Date: 31 July 2023
Our Reference: 23/06057/PMINMT

Conversion of existing outbuilding into 3 bed dwellinghouse, replacement and reduction of 2x polebarn into 2 x 3 bedroom dwellinghouses and conversion of existing polebarn into detached garage with associated amenity space, communal space, parking and landscaping at Land East Of Courtyard Barn Horseman Side Navestock Essex CM14 5SS

Rev	Date	Description	Checked
Project			
Land East of Courtyard Barn			
Title			
Proposed site plan with existing overlay			
Project No.	Scale	Drawing Size	
-	1:200	A3	
Drawing No.	Revision		
02	-

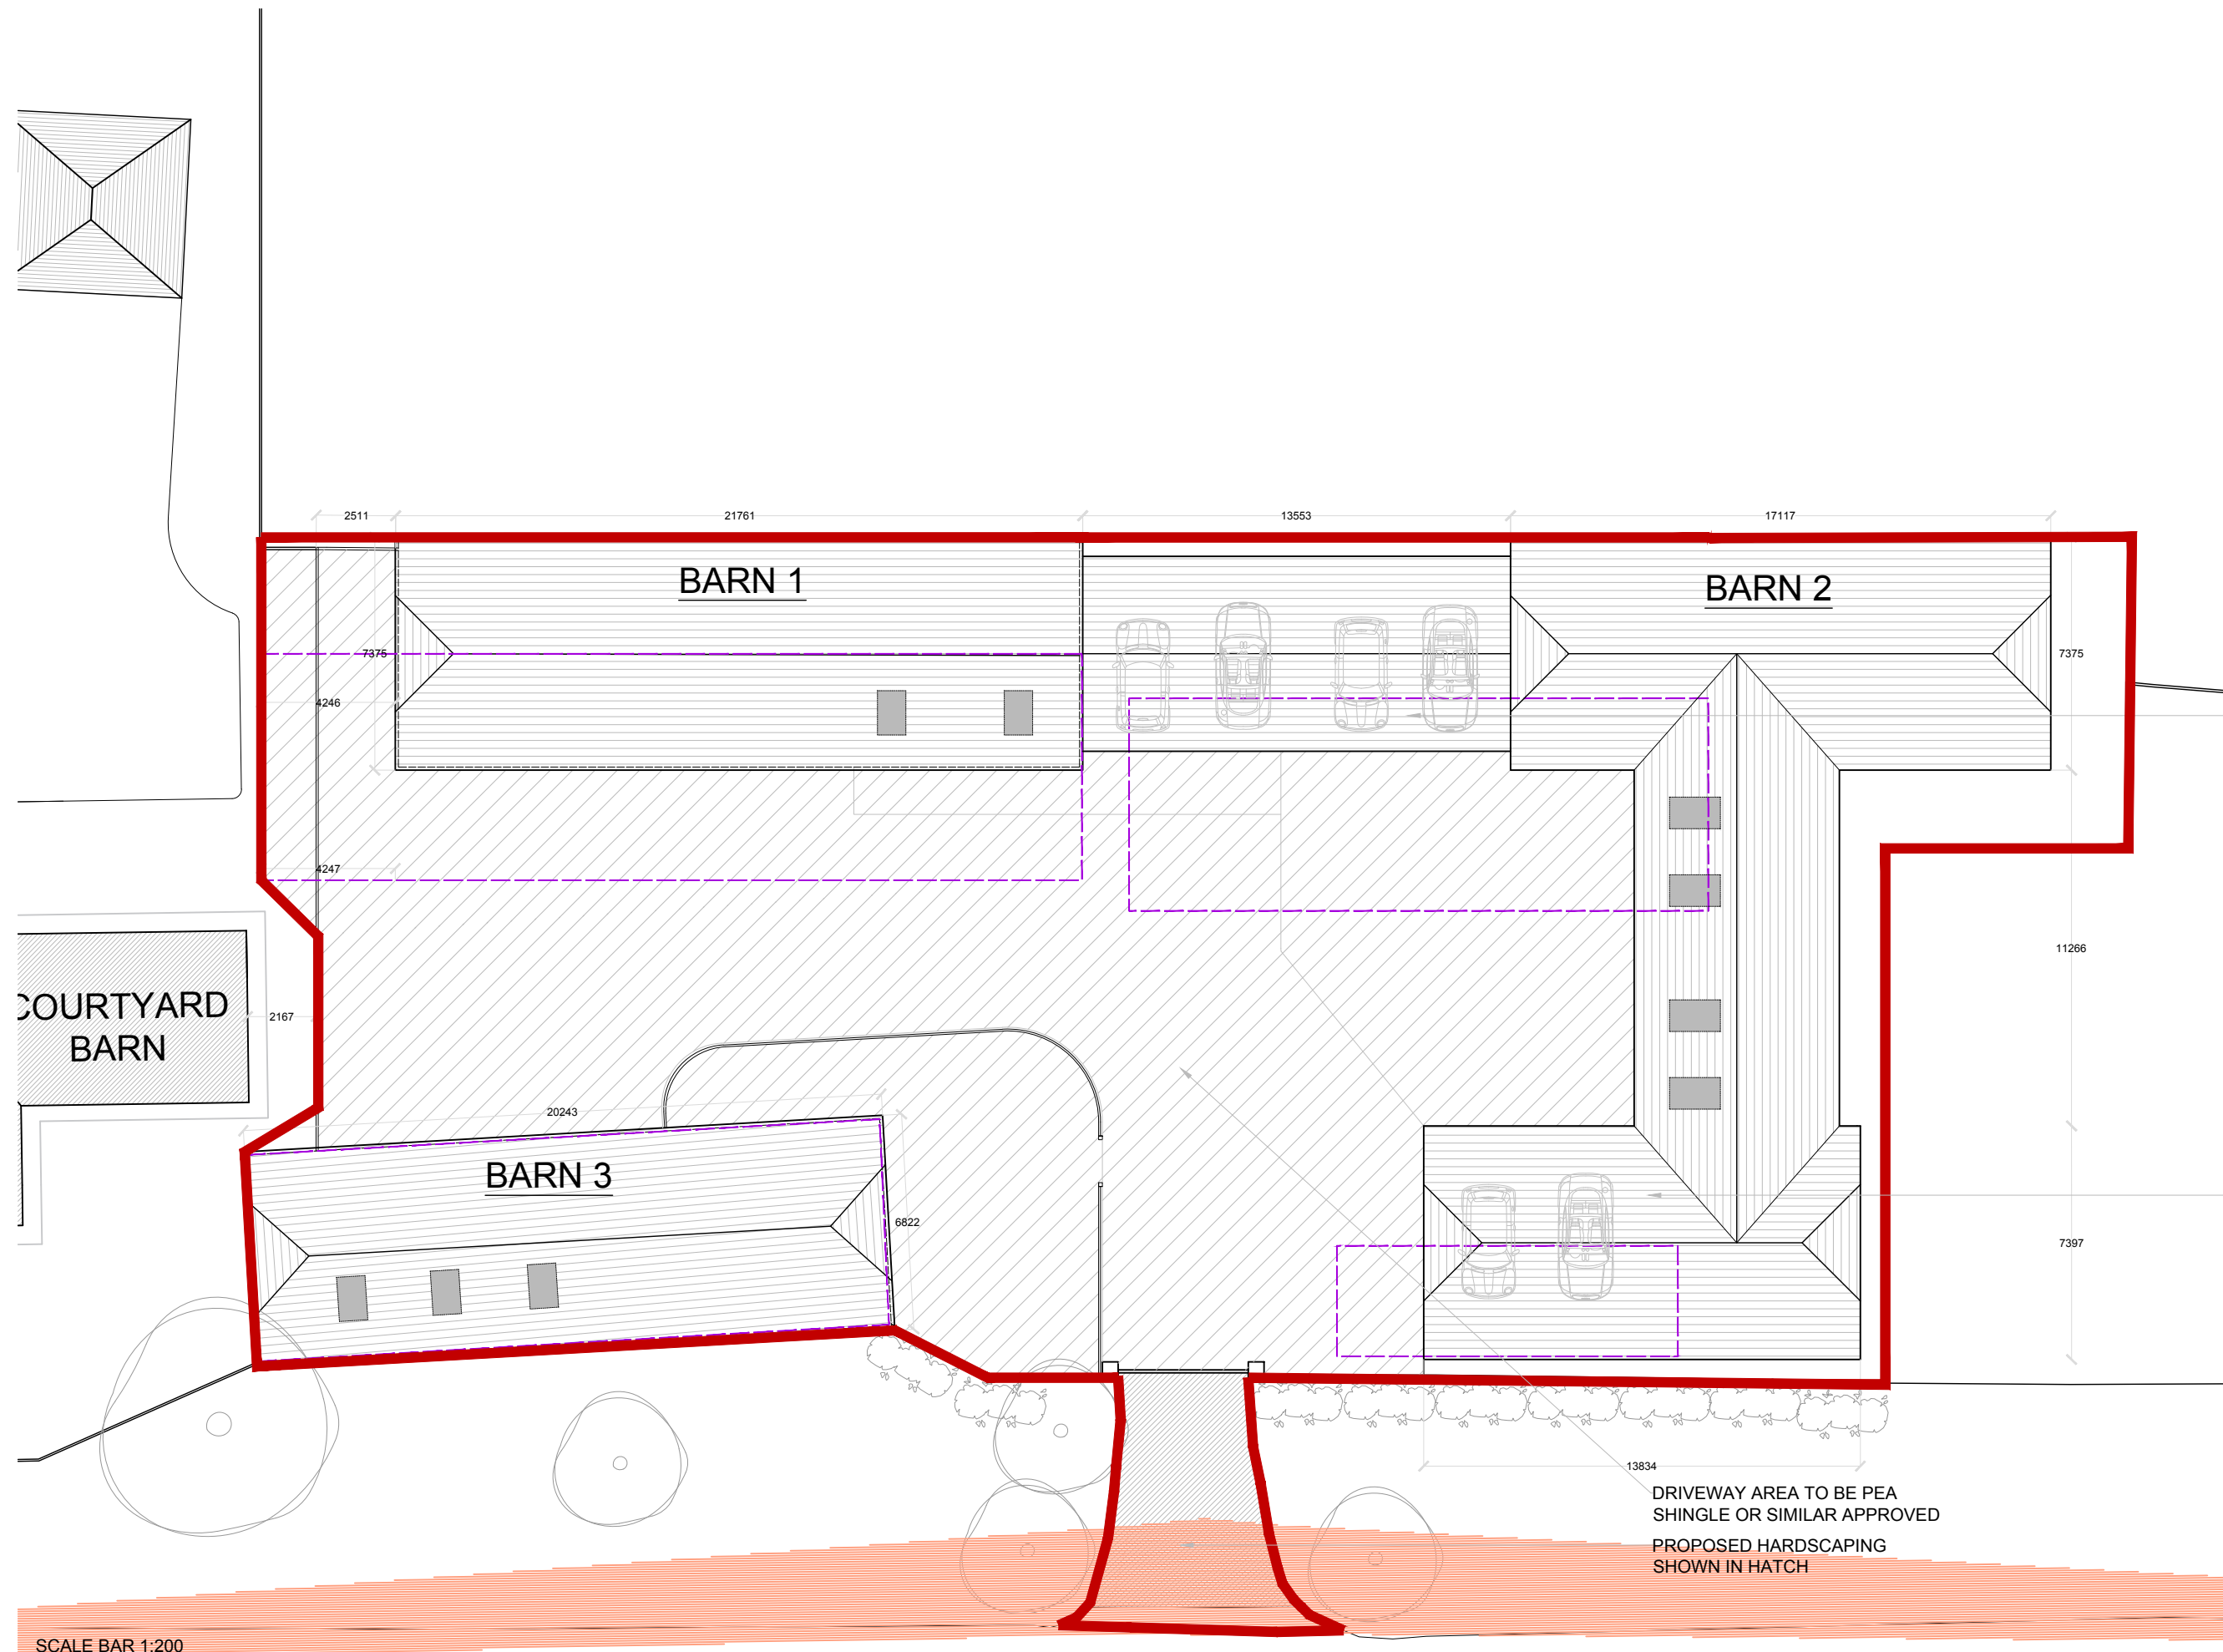
No visual overlays of the existing and proposed development have been provided, as we discussed on site that this type of drawing would be beneficial to see as it allows a comparison to show if the new development would visually and spatially impact upon the openness. During the meeting we discussed that the proposal was a preliminary submission in order to establish the principle and parameters of the site.

The development as submitted was not wholly supported by built heritage or planning due to its form, cramped feel of the siting of the buildings, parking and amenity spaces, location of parking, fenestration pattern and the potential of overlooking and loss of privacy to each other in habitable rooms and amenity space. As such we discussed during the meeting changes and a different approach could be taken to improve the proposal and impact upon the future occupiers as well as the heritage asset.

As discussed on site, the current layout raises concerns in regard to future living conditions and the units inter-overlooking into habitable rooms and not providing an area which is partly unoverlooked. Due to the close proximity of the units it was suggested greater analysis is required to the layout proposed, position of windows and layout of the amenity and parking areas in order to prevent overlooking from and into habitable rooms and providing an area of amenity space which is private and unoverlooked.

We discussed the relocation of the parking due to impacts upon the visual amenity and suggestions of design and siting alterations. The parking should be discreet, to the side of the dwellinghouse or within a carport.
